**KIRKLEES METROPOLITAN COUNCIL
INVESTMENT & REGENERATION SERVICE**

DELEGATED DECISION TO DETERMINE PLANNING APPLICATIONS

Reference No:	2022/62/90319/E
Site Address:	9, Tweed Close, Birstall, Batley, WF17 0PE
Description:	Erection of dormer to create enclosed roof terrace and application of render
Recommending Officer:	Elenya Jackson

DECISION - REFUSE

Revision	Description
Location	
9 Tweed Close Birstall Batley WF17 0PE	
Title	
Proposed Elevations	
Scale	
1 : 100 @A3	
Drawing No.	
S22367 / P-106	
Revision	
hello@spokelimited.co.uk tel: 0113 335 0975

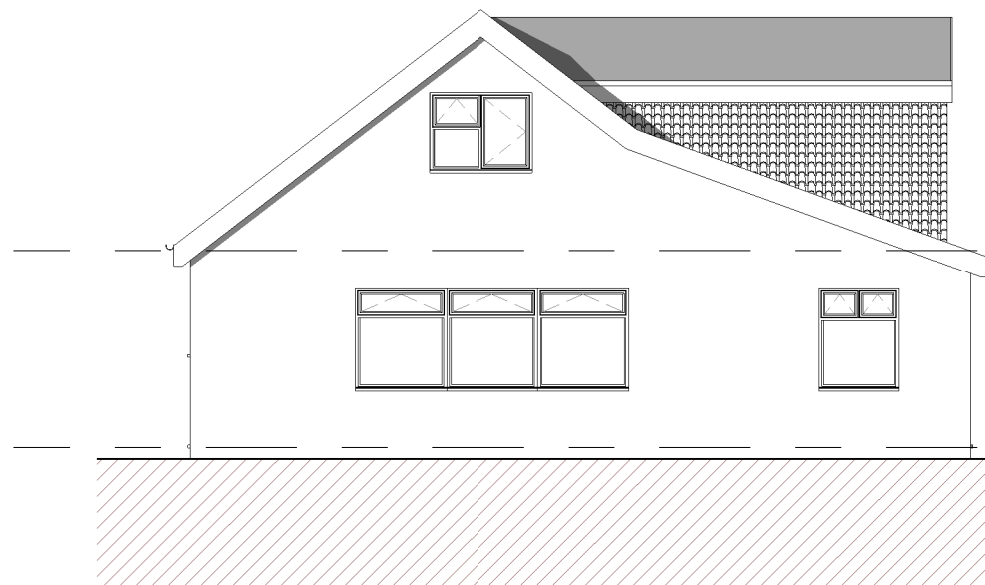
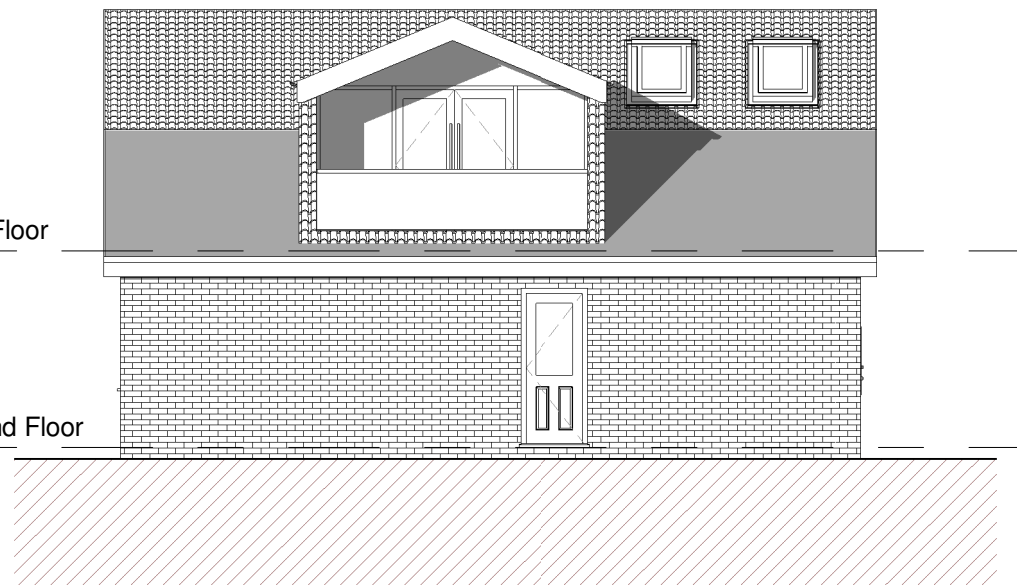
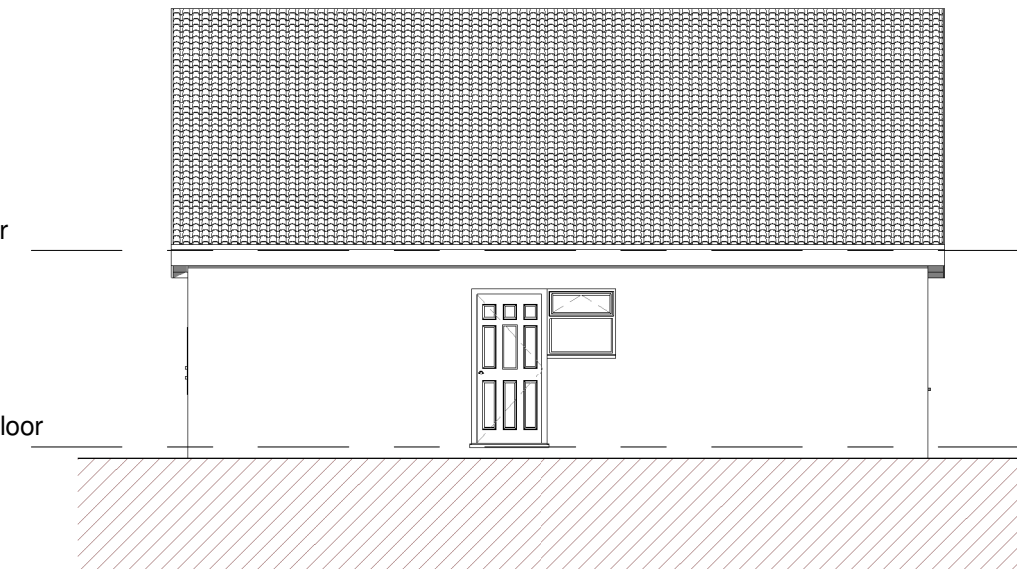
It is considered that due to the proposal projecting 6.1m beyond the plane of the roof, having a height of 2.6m and being situated on the side elevation of the existing dwelling, the proposal would appear overly dominant to the host dwelling, appear as an obvious addition within the street scene and fail to integrate with the wider character of the area.

It is acknowledged the existing dwelling features an a-symmetric roof; however, it is considered that the scale of the proposal would not assimilate within the existing roof space, would appear as an unconventional later addition, and further unbalance the appearance of the dwelling from the street scene.

The proposal would fail to respect the character of the original dwelling and would be read as a discordant feature within the street scene and wider in area. Therefore, the proposal fails to meet KLP policy 24 in terms of the character of the host property and the criteria of the House Extension SPD, particularly KDP 1 & 2 in terms of the character of the area and the impact on the house.

1. The proposed dormer and enclosed roof terrace, by reason of its projection, overly prominent location, domineering appearance and scale would have a harmful effect on the character of the host property and in turn, the prevailing character of the area. To permit the rear extension would be contrary to policy LP24 of the Kirklees Local Plan in terms of its scale, form and layout, KDP1 & KDP 2 of the House Extension SPD and advice within chapter 12 of the National Planning Policy Framework.

2. The application of render to the external elevations of 9 Tweed Close are considered to fail to respect the character of the original dwelling, the street scene, and the prevailing character of the area. To retrospectively permit the application of render would be contrary to policy LP24 of the Kirklees Local Plan in terms of its scale, form and layout, KDP1 & KDP 2 of the House Extension SPD and advice within chapter 12 of the National Planning Policy Framework.
